from
**Southern
Water**

Our ref
PLAN-039734

Proposal: Approval of details reserved by condition imposed under ref LU/287/17/PL relating to Condition Nos 7 - divert public sewers and 8 - foul & surface water sewerage disposal.

Site: LU/111/21/DOC: - 46a & 47 Pier Road and Land North of Clifton Road, Littlehampton, BN17 5LW.

P5	NOTE 17 ADDED AND KEY UPDATED.	20.05.21	MGC
P4	AMENDED TO SUIT SOUTHERN WATER COMMENTS	22.02.21	MGC
P3	DRAINAGE AMENDED TO SUIT LLFA COMMENTS	15.01.21	MGC
P2	MANHOLE SCHEDULES ADDED	10.12.19	MGC
P1	PRELIMINARY ISSUE	04.12.19	MGC
REV	AMENDMENT	DATE	CHKD

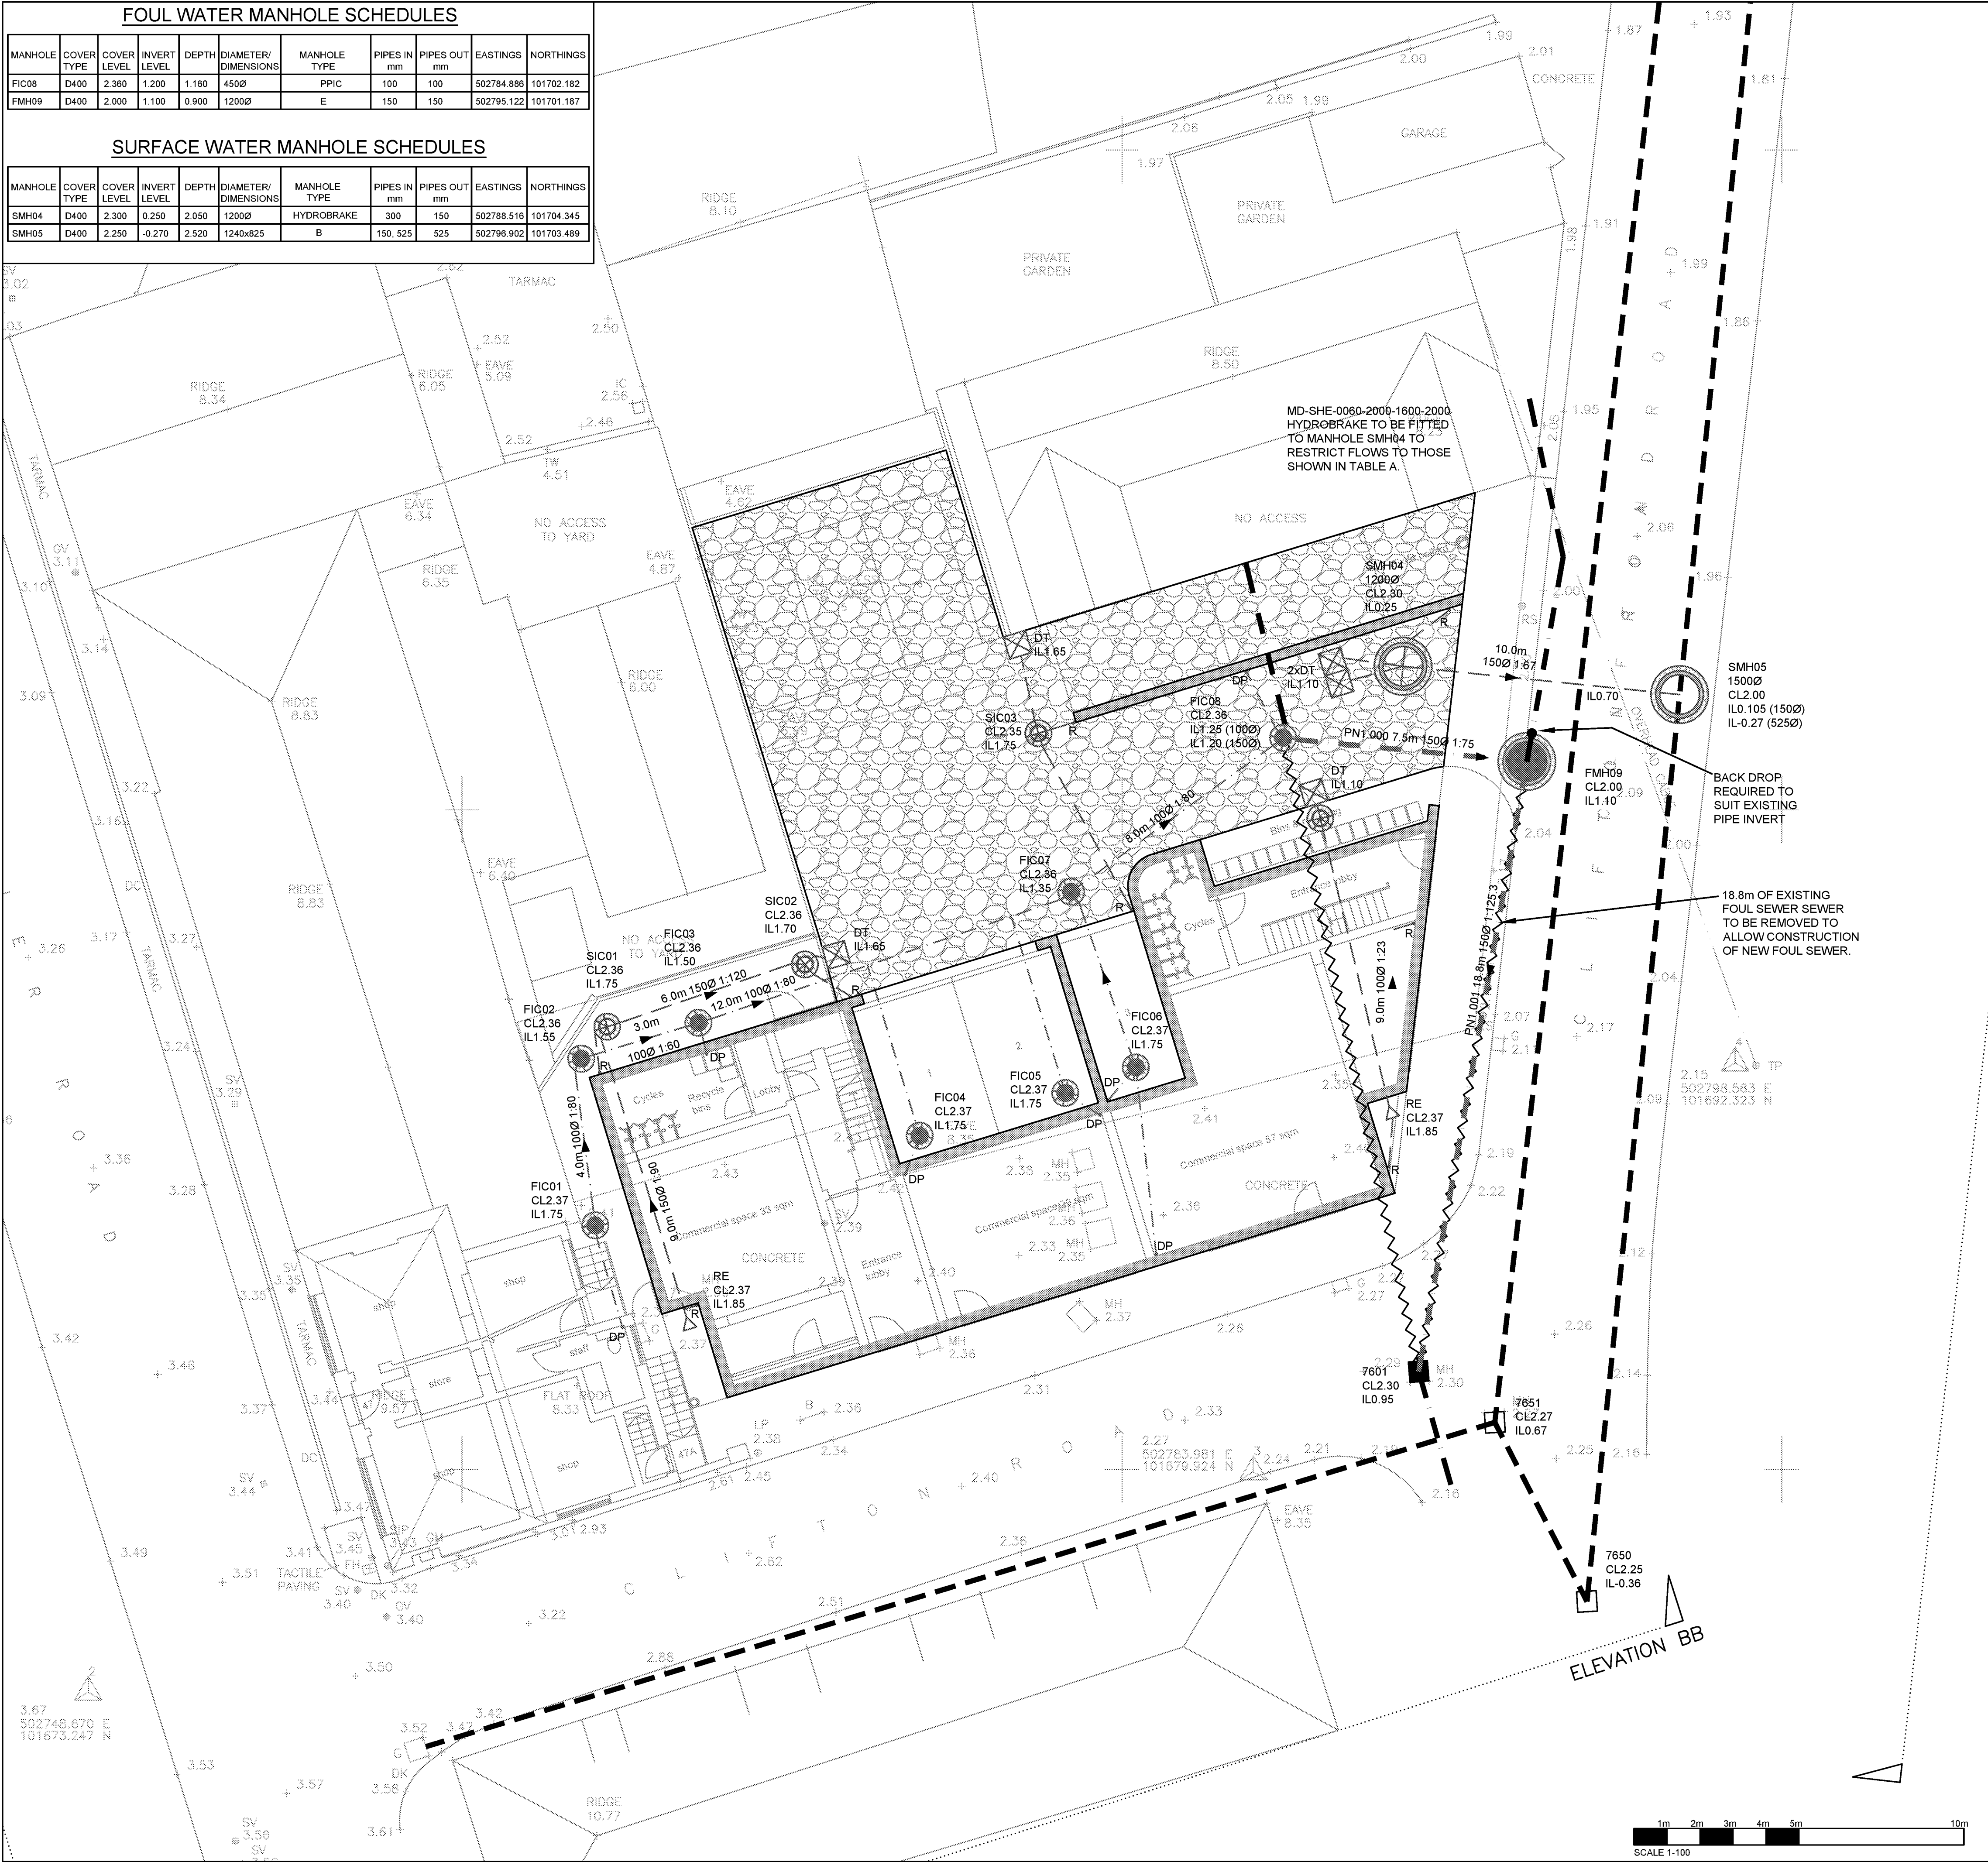
Further to our previous correspondence dated 30/04/2021 regarding the above planning consultation and further information provided by the developer regarding proposed tanked storage system.

Southern Water shall have no objections to discharge condition 08 regarding surface water drainage. Surface water may be discharged to the existing sewer, provided the rate of discharge to sewer is no greater than existing contributing flows. An approval for the connection to the public sewer should be submitted under Section 106 of the Water Industry Act.
